Welwyn Hatfield Borough Council

Application for removal or variation of a condition following grant of planning permission. Town and Country Planning Act 1990. Planning (Listed Buildings and Conservation Areas) Act 1990

Number	<input type="text" value="15"/>
Suffix	<input type="text"/>
Property name	<input type="text"/>
Address line 1	<input type="text" value="Station Road"/>
Address line 2	<input type="text" value="Cuffley"/>
Address line 3	<input type="text"/>
Town/city	<input type="text" value="Potters Bar"/>
Postcode	<input type="text" value="EN6 4HX"/>

As Built or On Site changes have resulted in changes to conditions requiring agreements.

bin stores as built

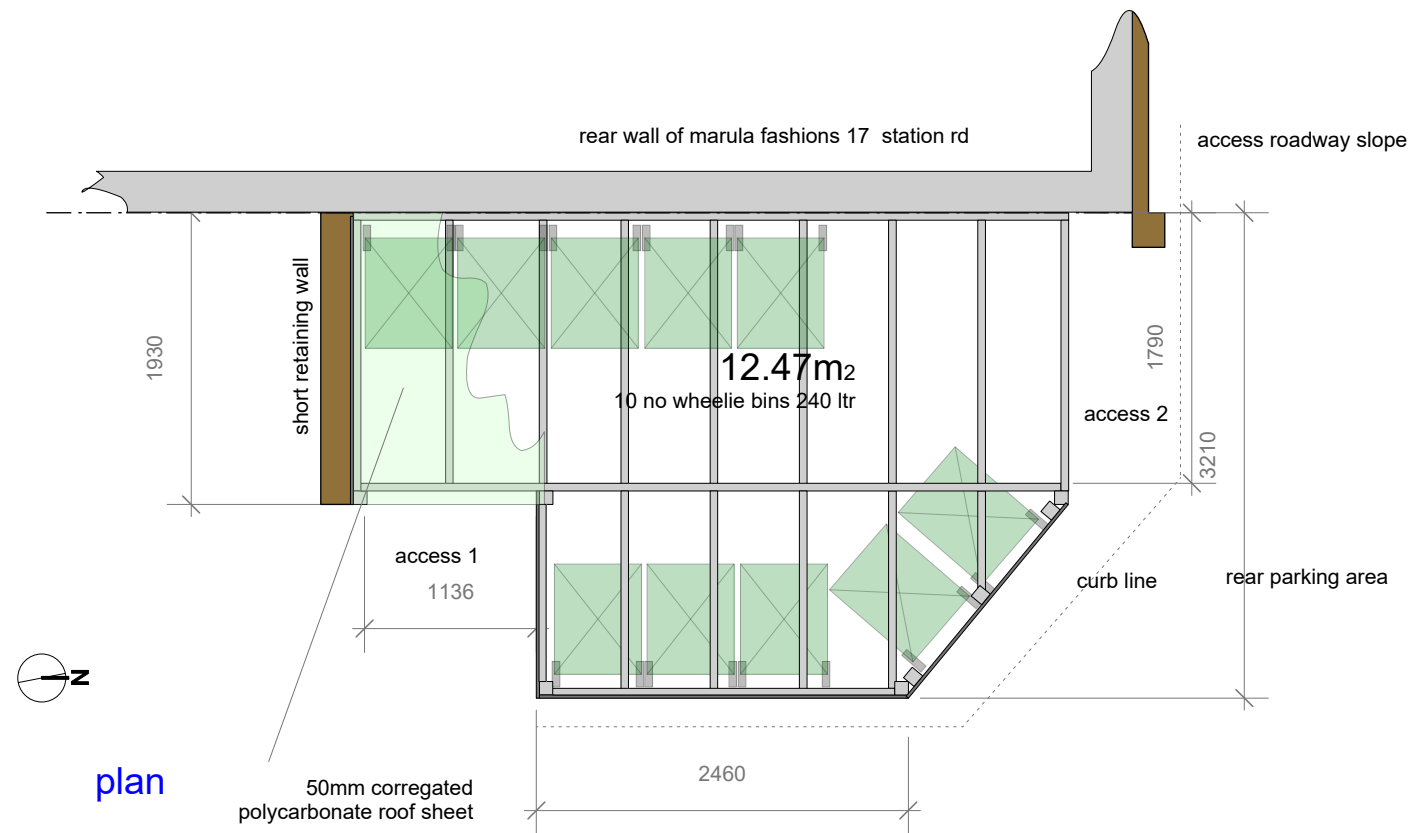
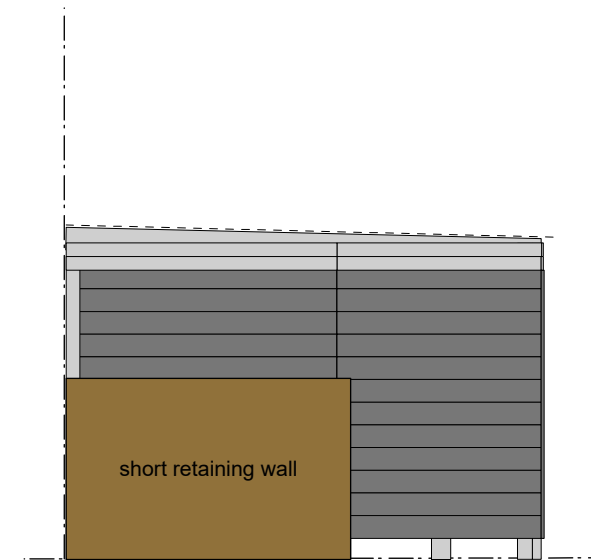
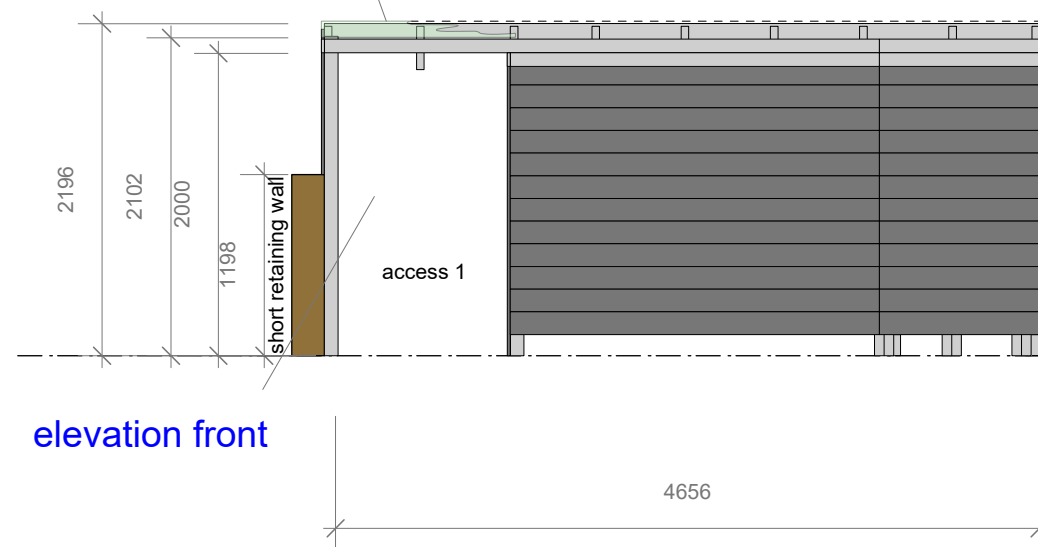
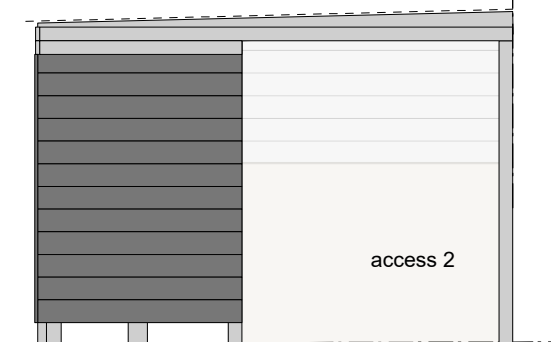
I received a telephone call a couple of weeks ago from the property owner about the re-located bin store and reasoning. I advised that an application for full planning permission is required for the bin store structure.

PLEASE CAN WE APPLY TO HAVE THIS ARE AGREED FOR THE CURRENT BIN AND BIKE STORE STRUCTURE AS PART OF DISCHARGE OF CONDITIONS WHERE DIFFERENT TO EXISTING APPROVED LOCATION.
